**Section 96A of the Town & Country Planning Act 1990 (as amended)
Town and Country Planning (Development Management Procedure) (England) Order 2015 (as amended) - Article 10**

Non-material amendment following grant of BE/135/18/PL for Unit 5 plans, elevations and sections updated to include: Canopies over drive-thru windows added, drive-thru windows revised, curtain walling mullions/transoms re-positioned, roof colour corrected, cantilevered beams added to roof overhang

Land At Salt Box West Of Shripney Road Bognor Regis PO22 9NW

MountfordPigott
Architecture Masterplanning Design
DRIVE THRU 2
PROPOSED ELEVATIONS
1744-DT2-P03-C
1:50@A1/1:100@A3
DRAWN BY ACD
07.12.18

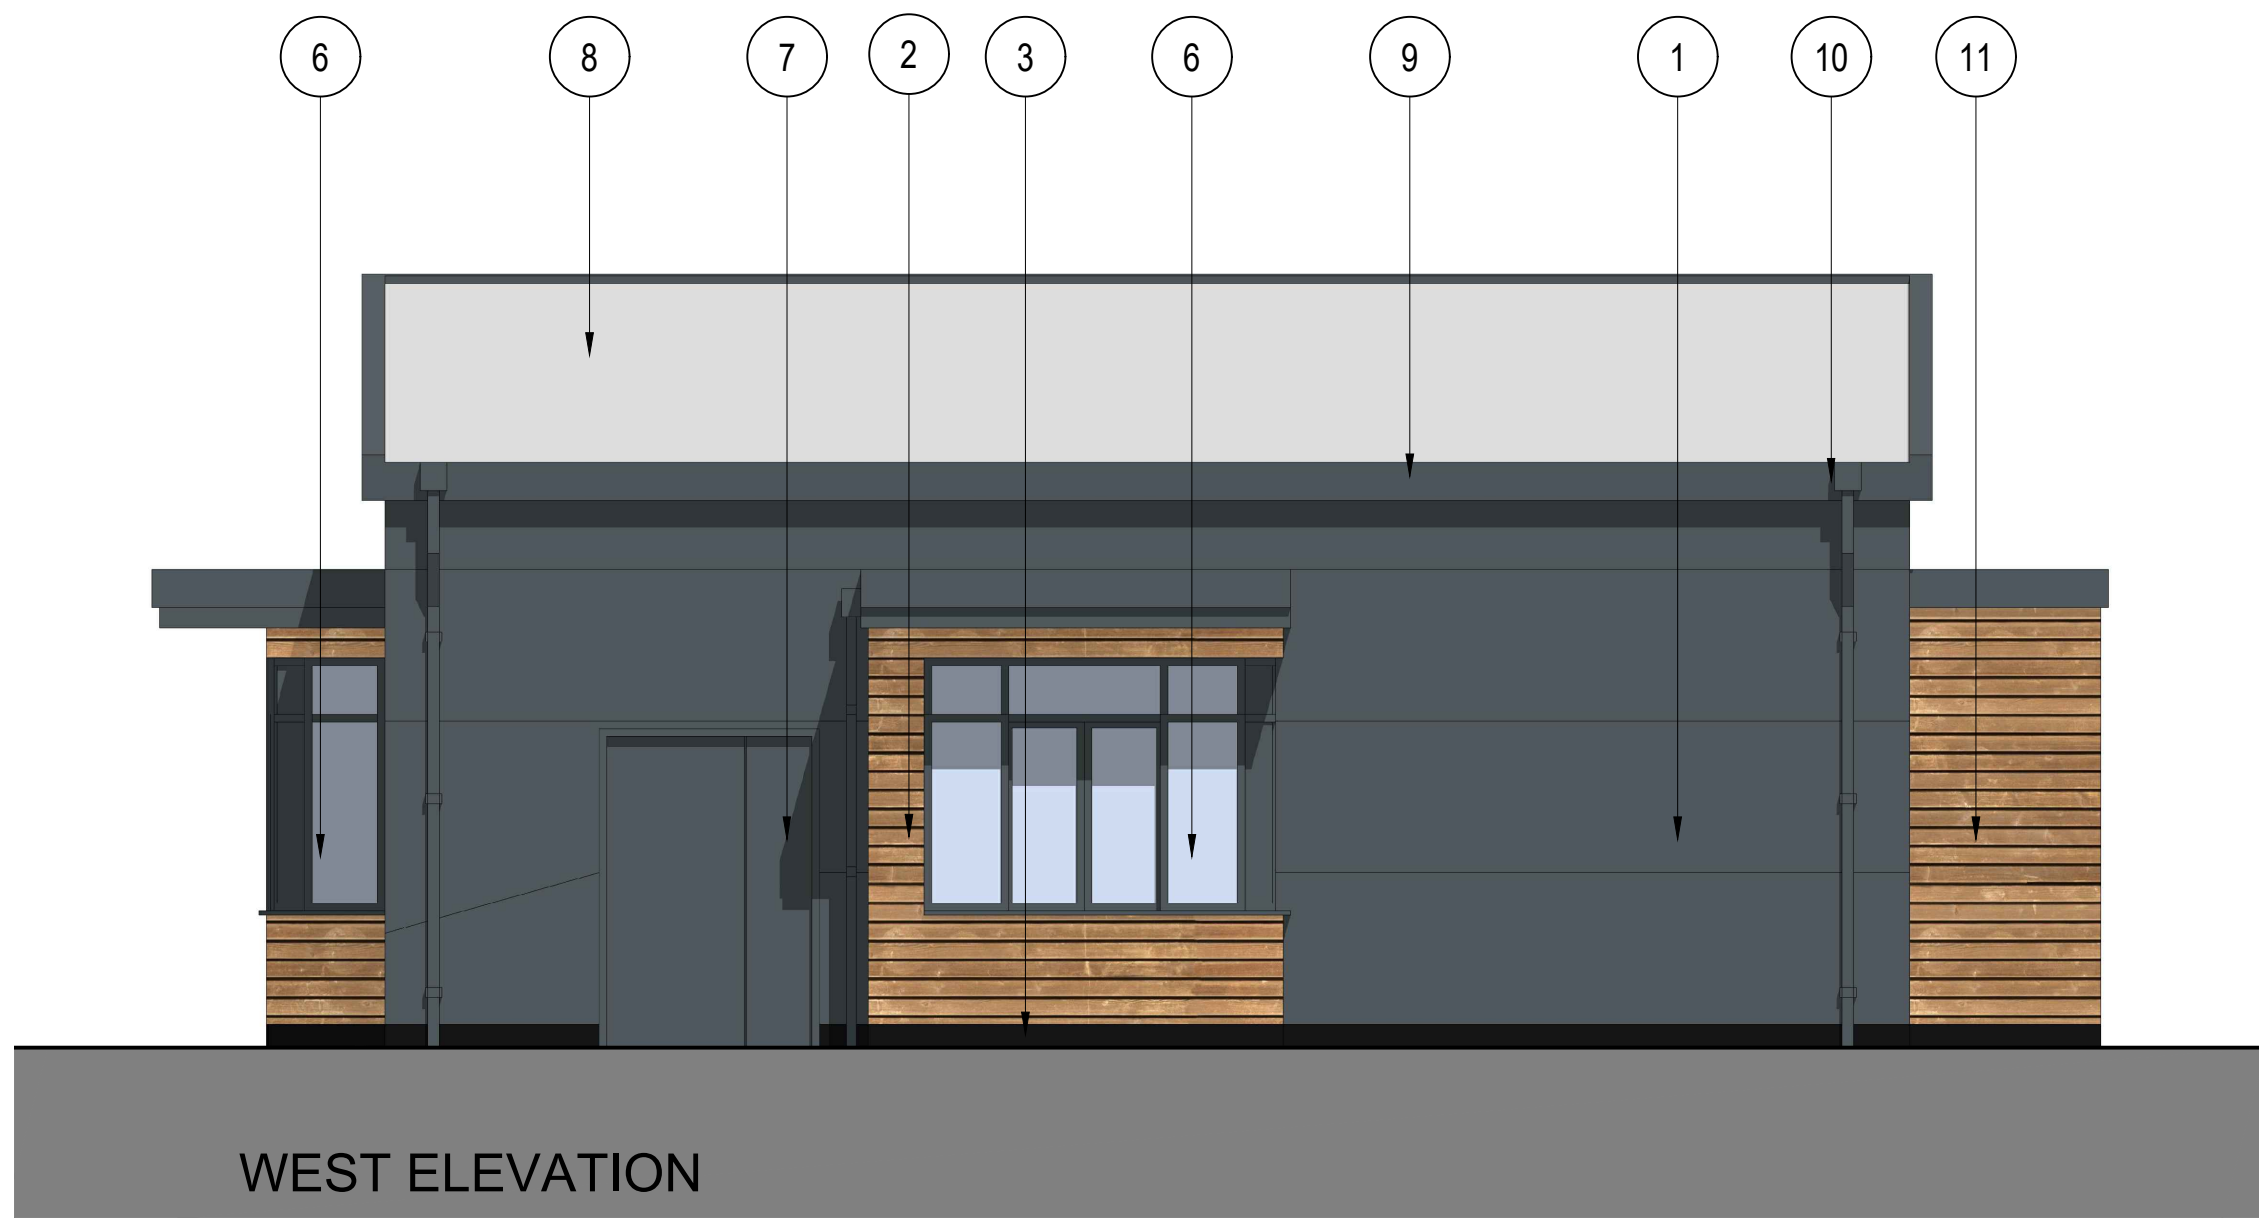
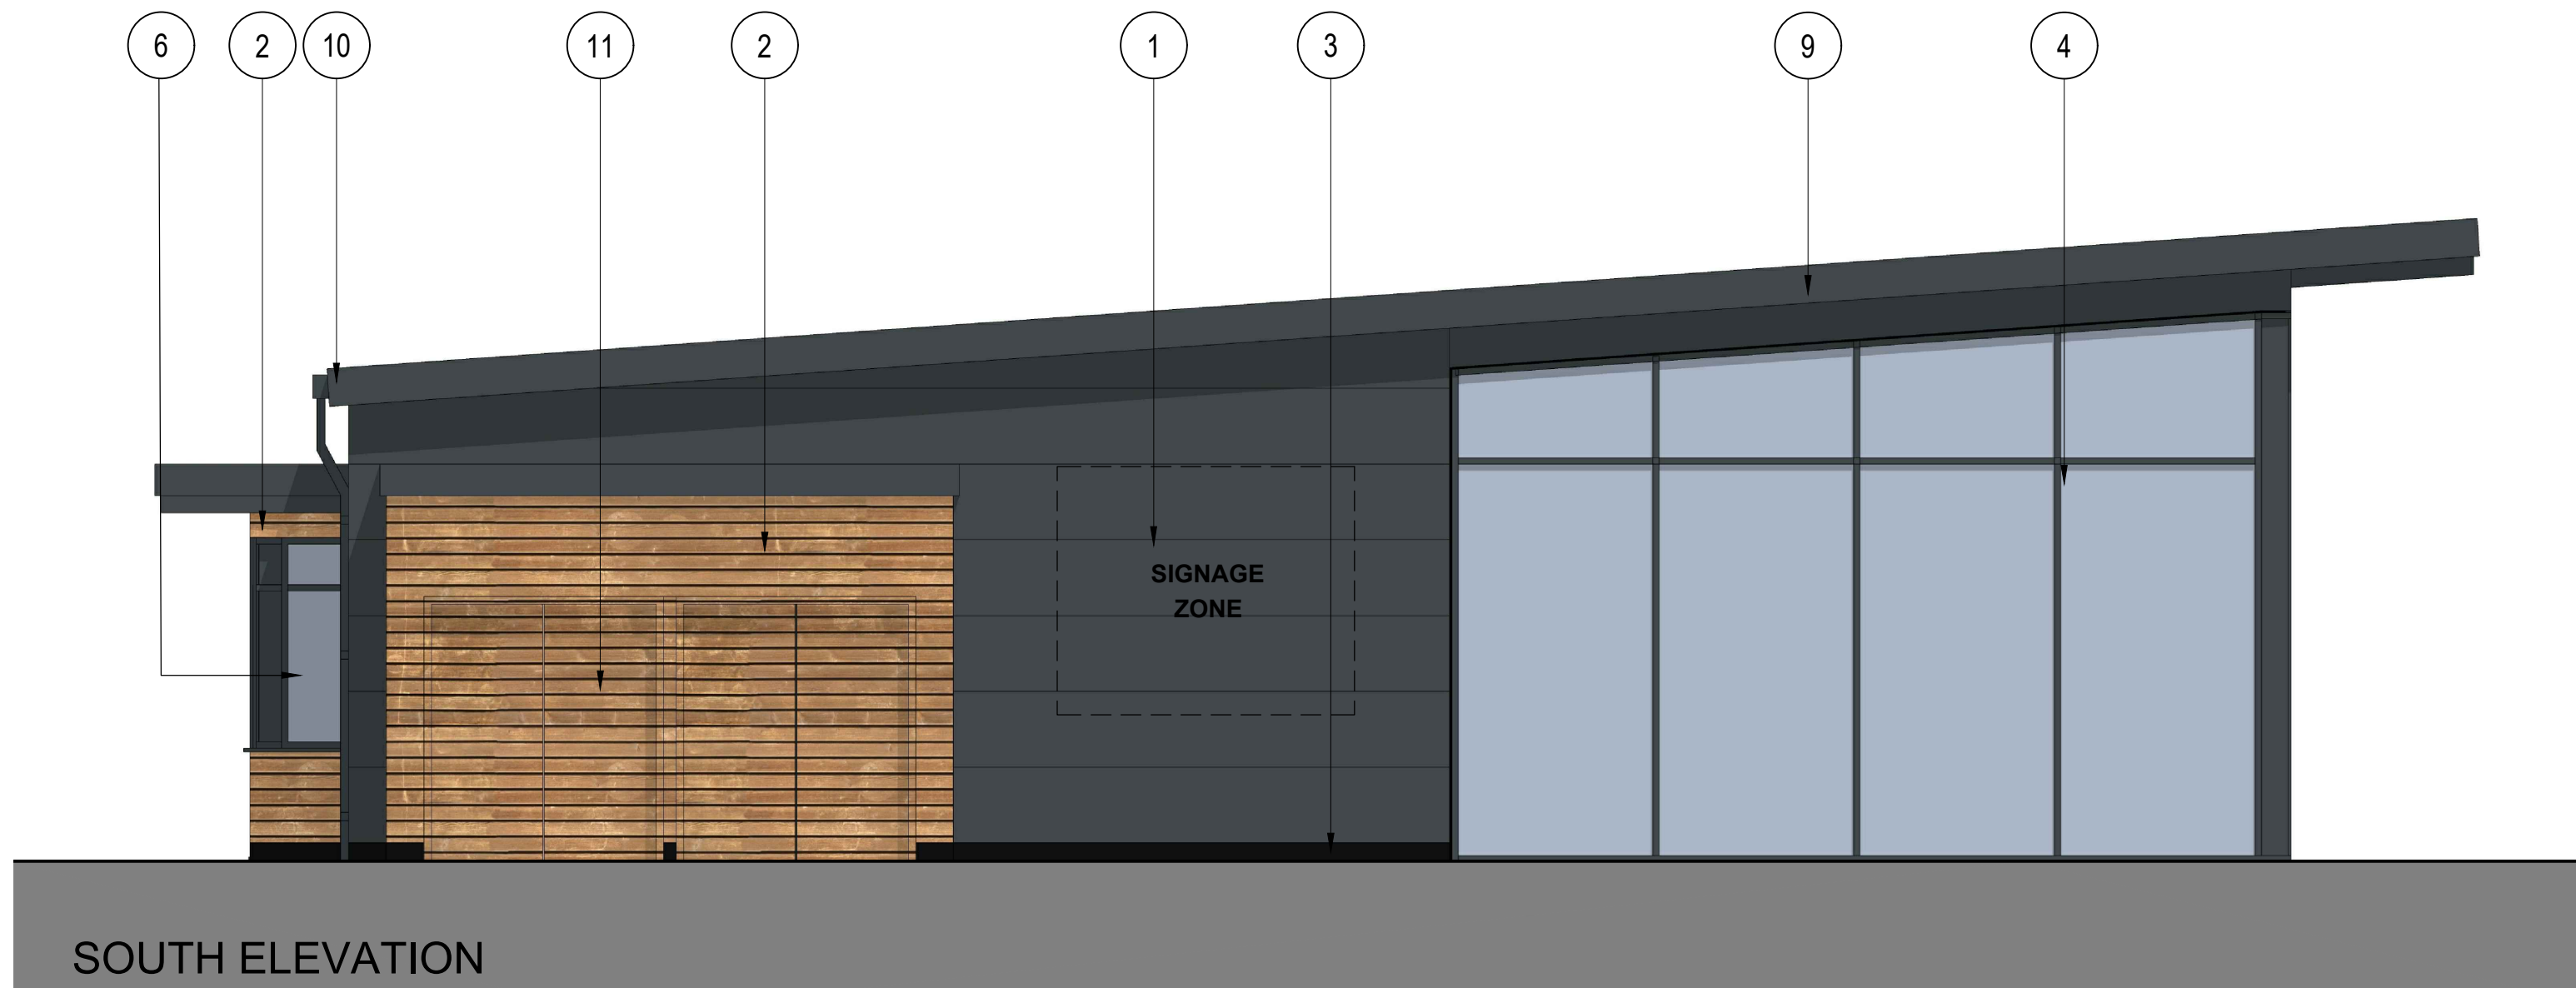
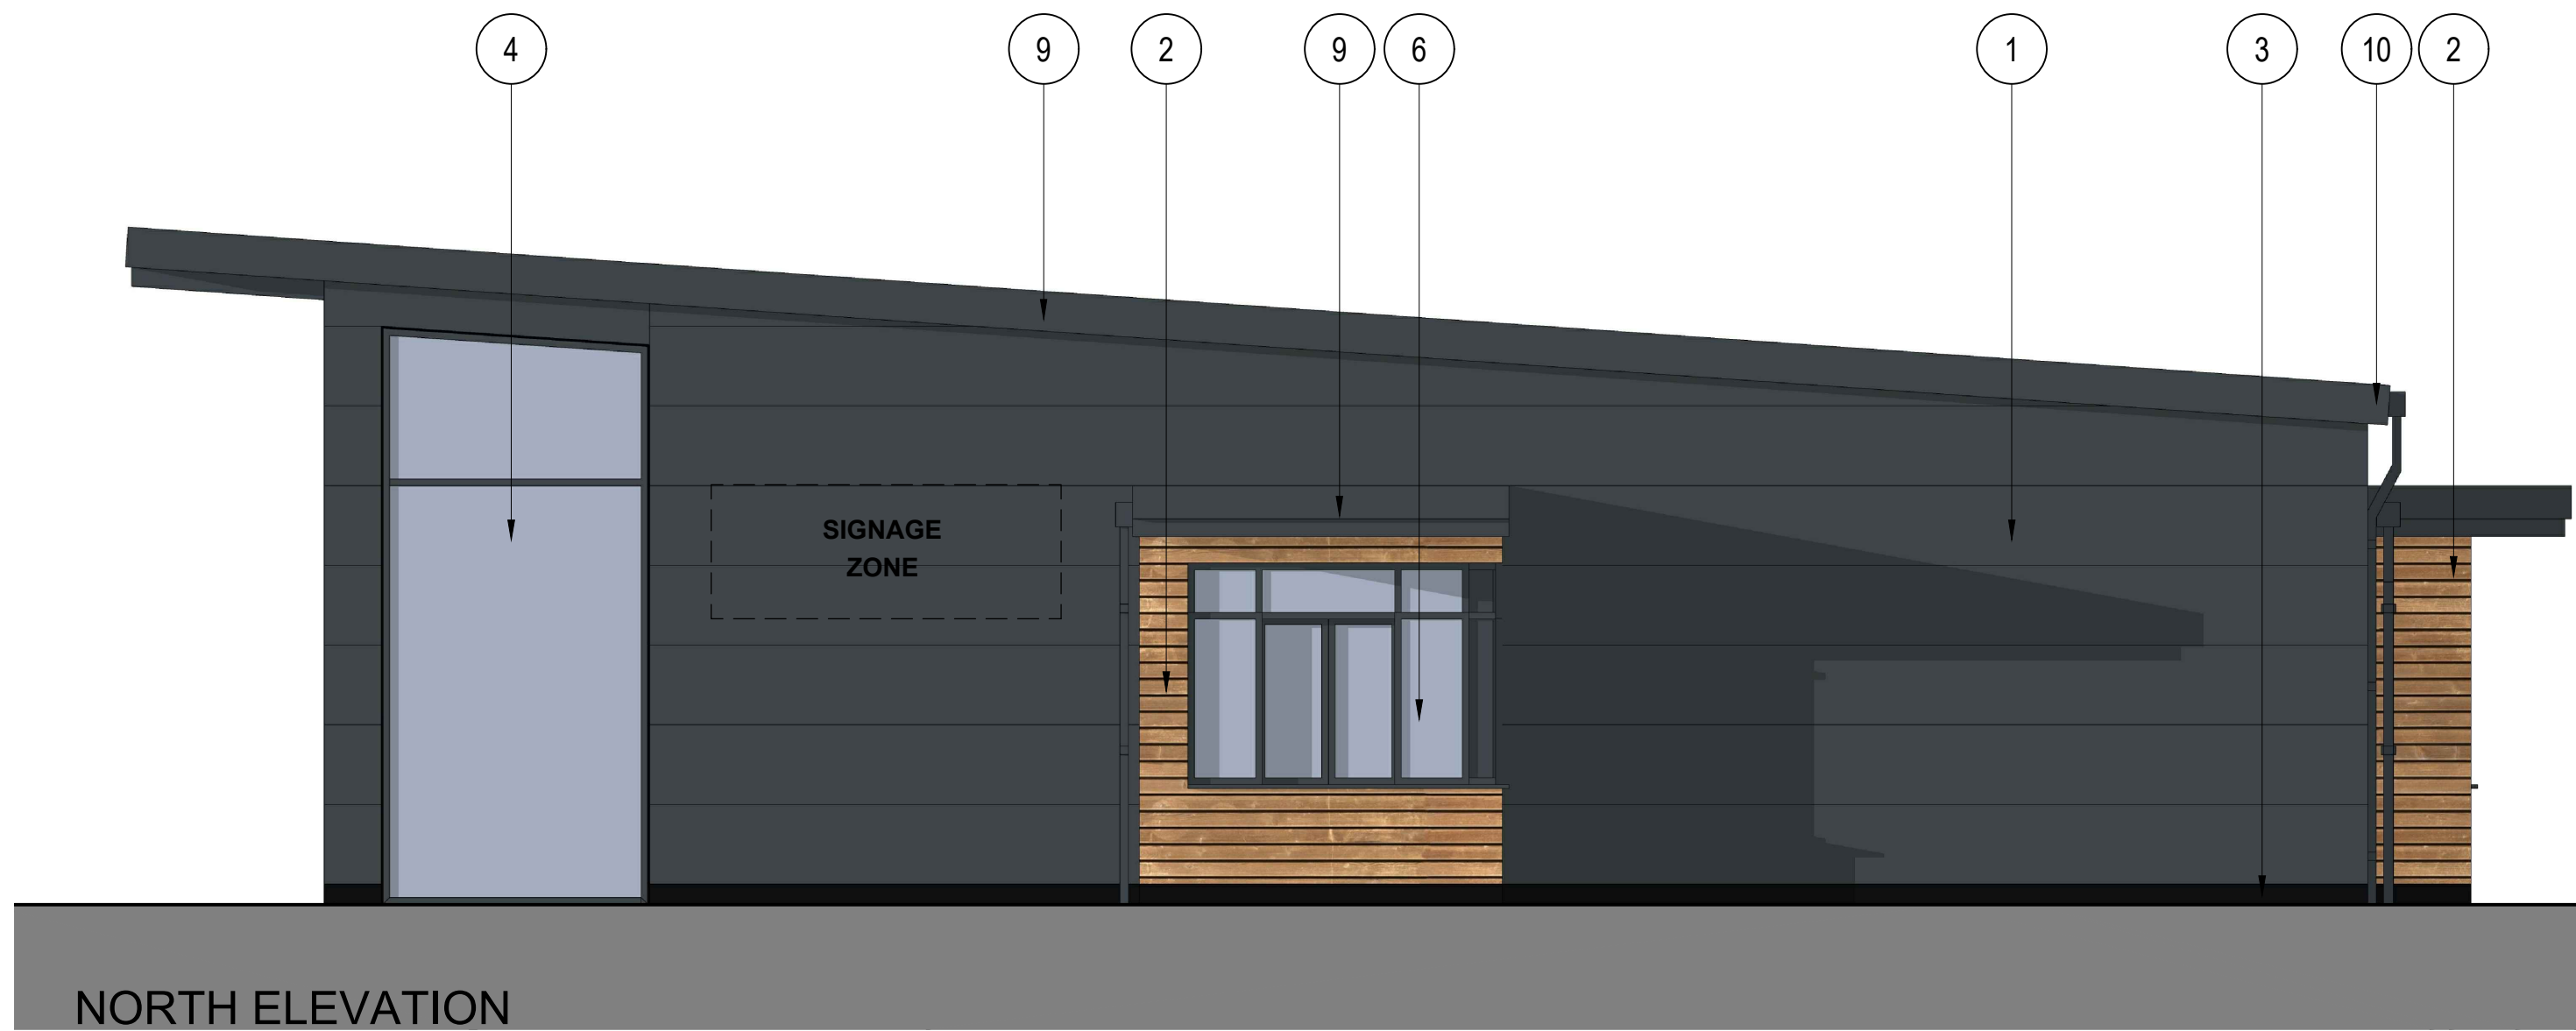
The reason that this proposal has been accepted as a Non-Material Amendment is because it regularises a change on site which comprises alterations to the elevations and sections of Unit 5 (i.e. Drive Thru 2) to include canopies over the drive-thru windows, drive-thru windows revised, curtain walling mullions/transoms re-positioned, the roof colour corrected, and cantilevered beams added to the roof overhang, and it can therefore be considered under section 96A of the Town and Country Planning Act 1990.

Please note that Drawing No. 1744-DT2-P02 Rev. B - Drive Thru 2 Ground Floor Plan, Drawing No. 1744-DT2-P03 Rev. C - Drive Thru 2 Proposed Elevations and Drawing No. 1744-DT2-P04 Rev. B - Drive Thru 2 Proposed Sections now form part of the approved planning documents and drawings for
